COUNTY COUNCIL'S RESPONSE TO CONSULTATION ON THE FOLLOWING DEVELOPMENT PROPOSAL

Application No: 19/00441/REM

Proposal: Reserved Matters to 13/01811/OUT - Dorchester Phase 5, comprising the provision of seven open market dwellings with associated landscaping, car parking, infrastructure and external works.

Transport Schedule

SCALE: 1:500 @ A3  
 DATE: DECEMBER 2018 DRAWING TITLE: REFUSE PLAN  
 DRAWN: DGK DRAWING NO: 0521-PH5C-5D-5(R)-111

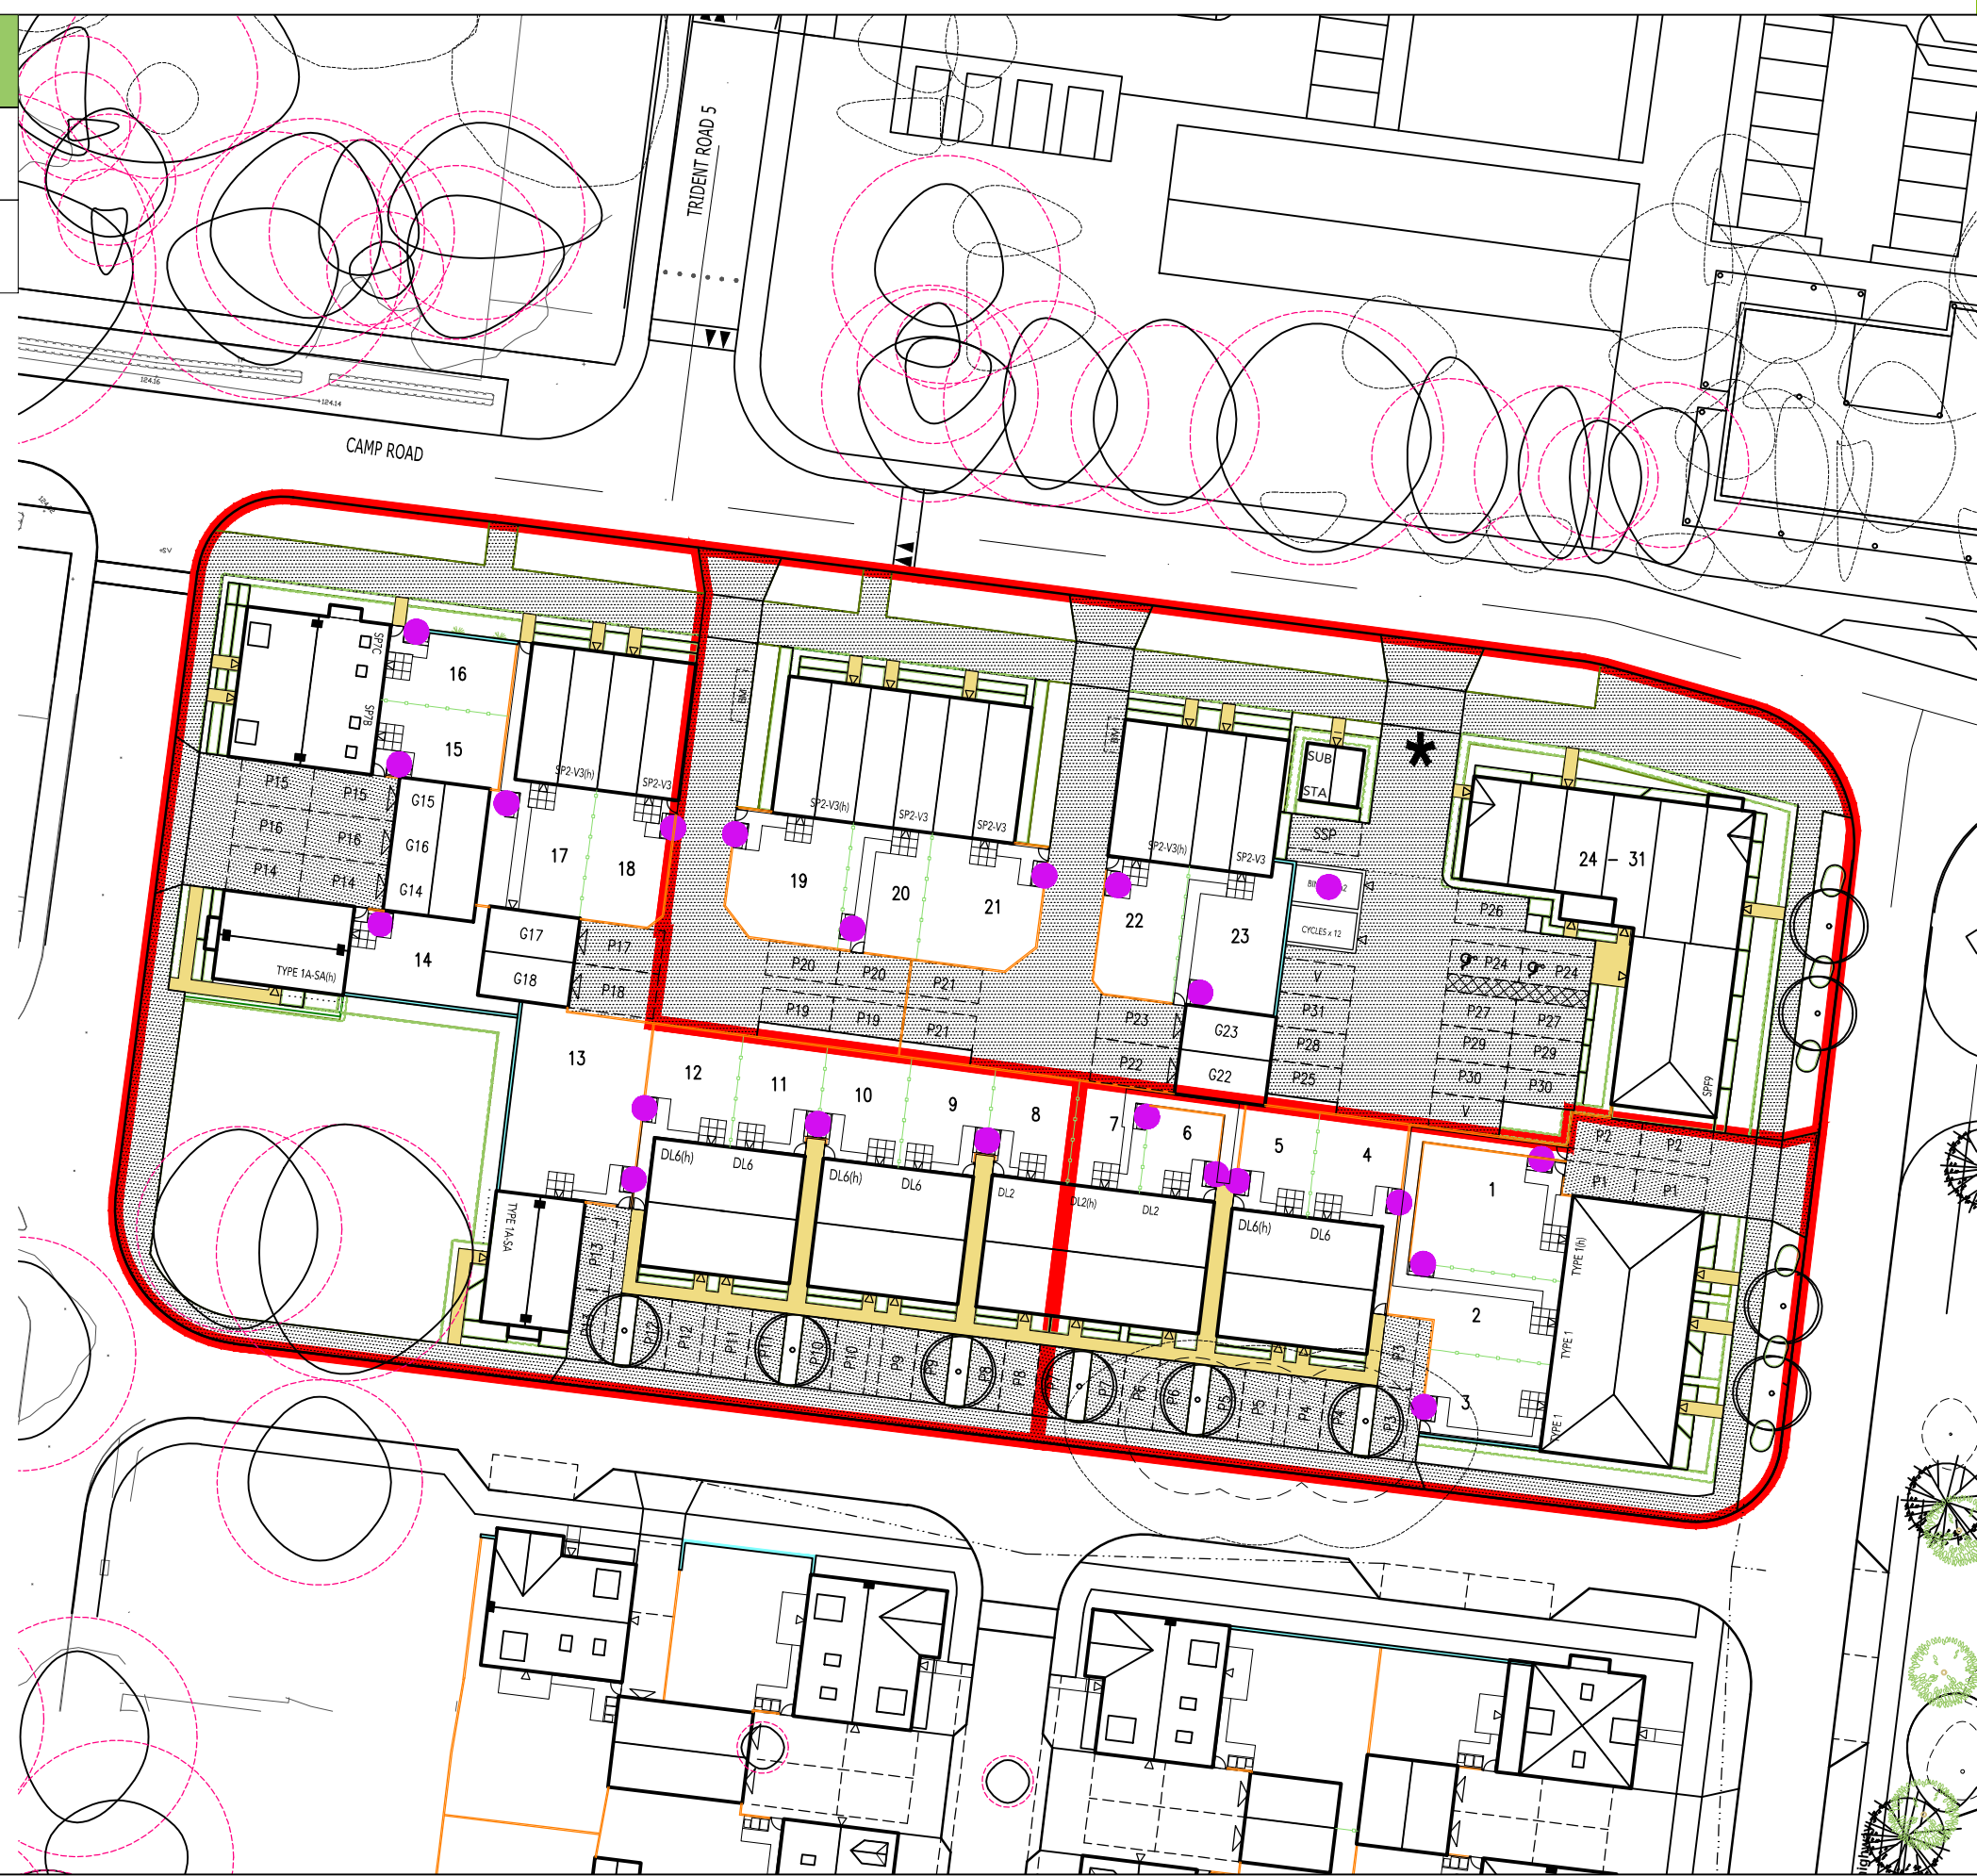
The planning application does not include any vehicle tracking. Vehicle swept path analysis is required to demonstrate access to parking spaces and suitable access for refuse and emergency vehicles. **Reason for objection.**
